# City of Albuquerque

RE: DRAINAGE PLAN FOR HORIZON NURSING CENTER  
(K-15/D50) RECEIVED MAY 10, 1989

I have reviewed the referenced plan and forward the following comments:

GRADING AND
DRAINAGE PLAN

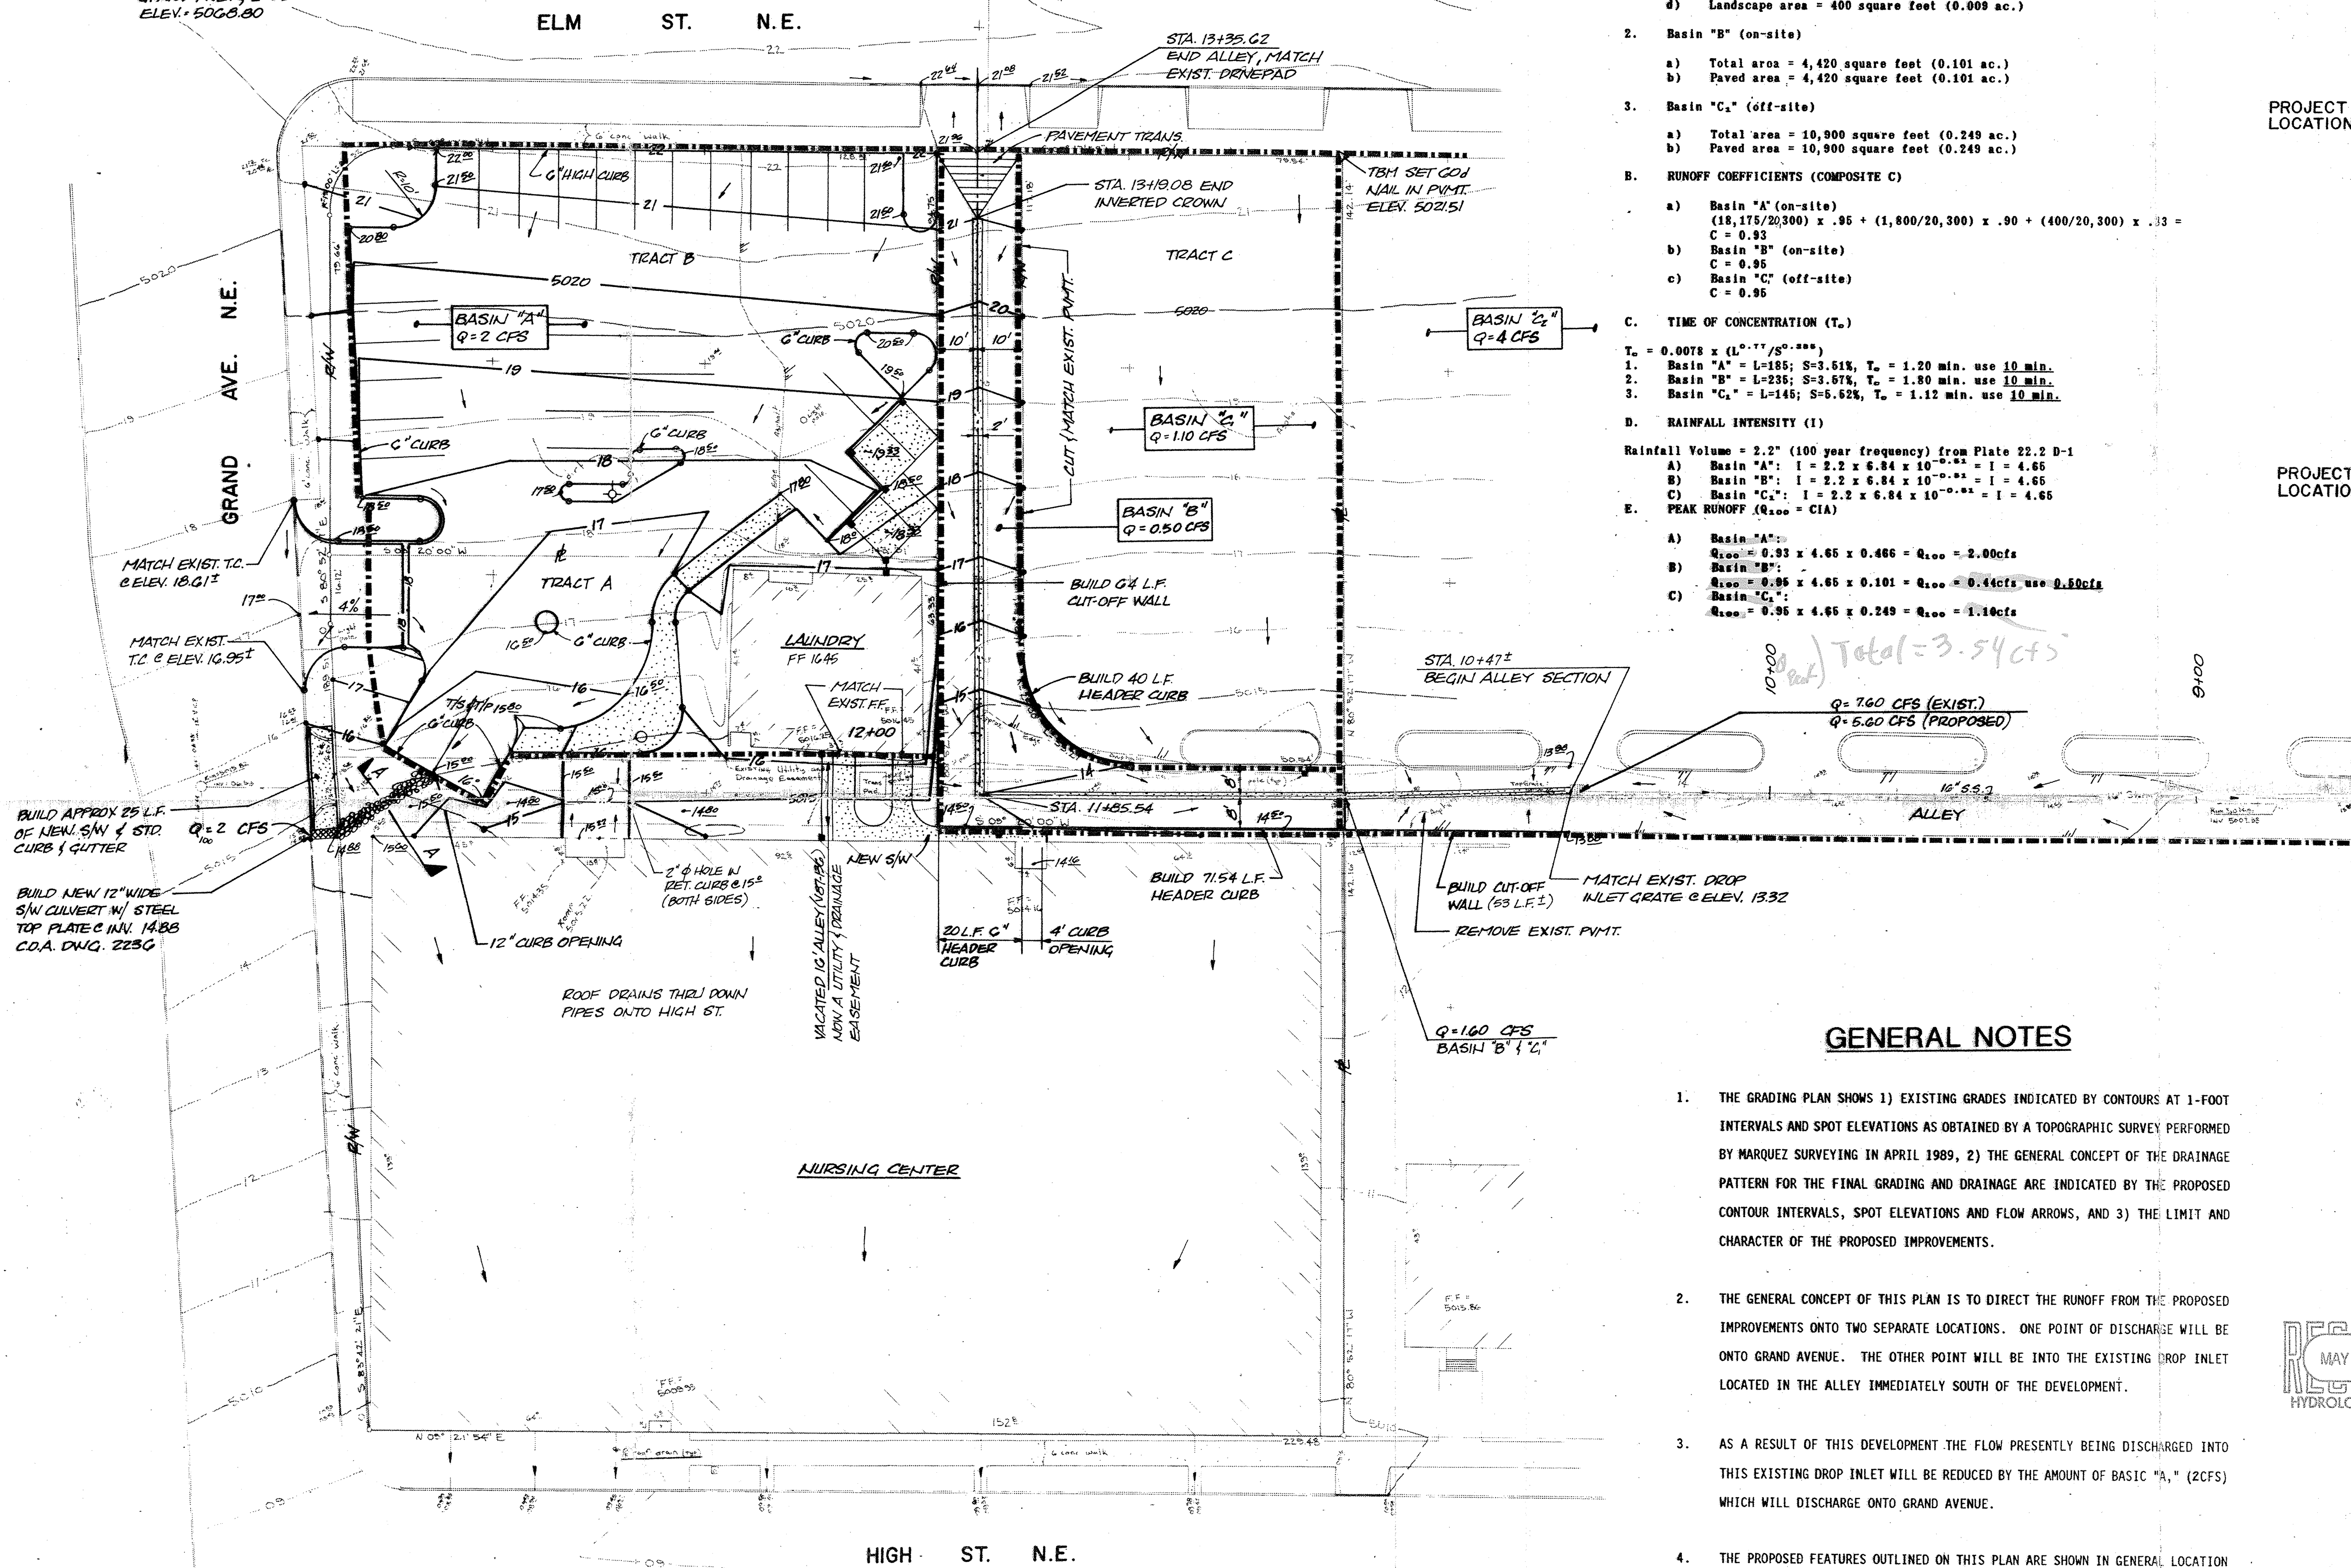
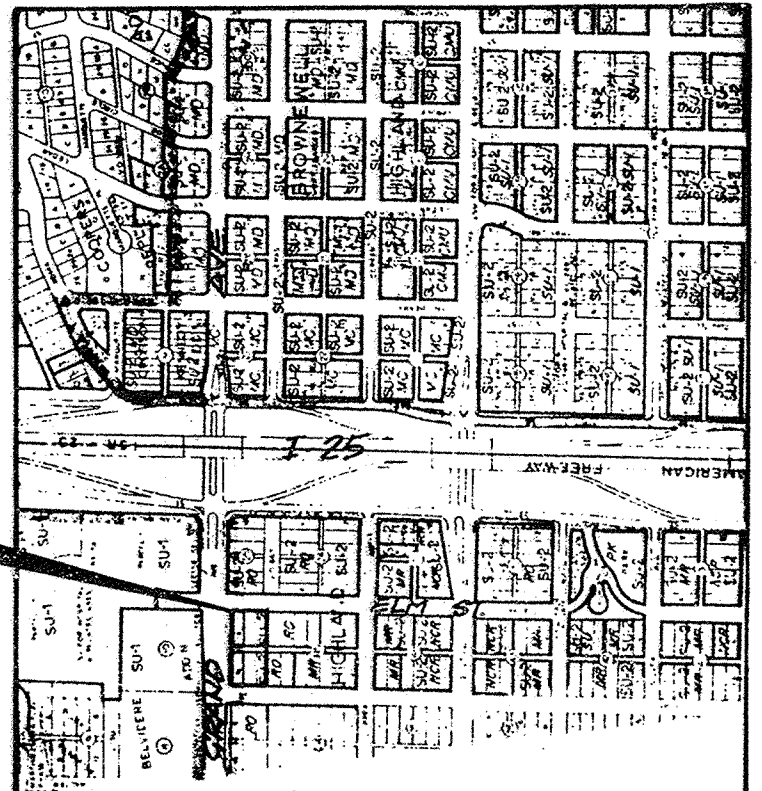
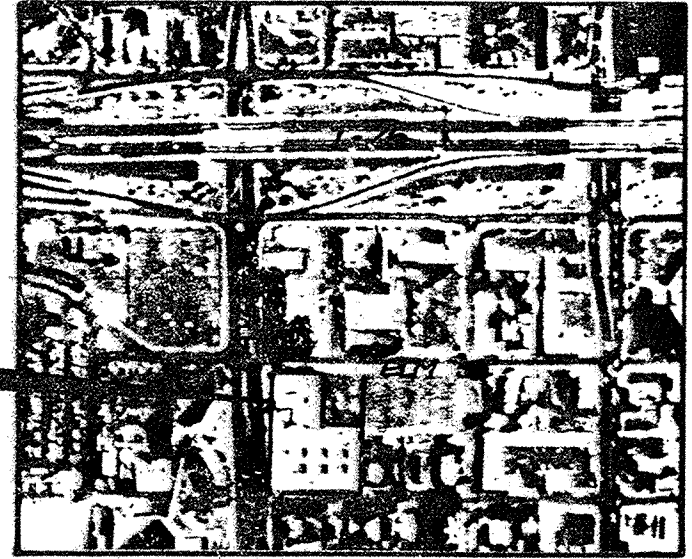
- ✓ 1. Please show roof drain.
- ✓ 2. Need a one foot water block for the entrance from Grand Avenue.
- ✓ 3. Please show where there is a 6" curb.
- ✓ 4. Will there be new curb and gutter at the sidewalk culvert area? *yes*
- ✓ 5. Please correct your time of concentrations.
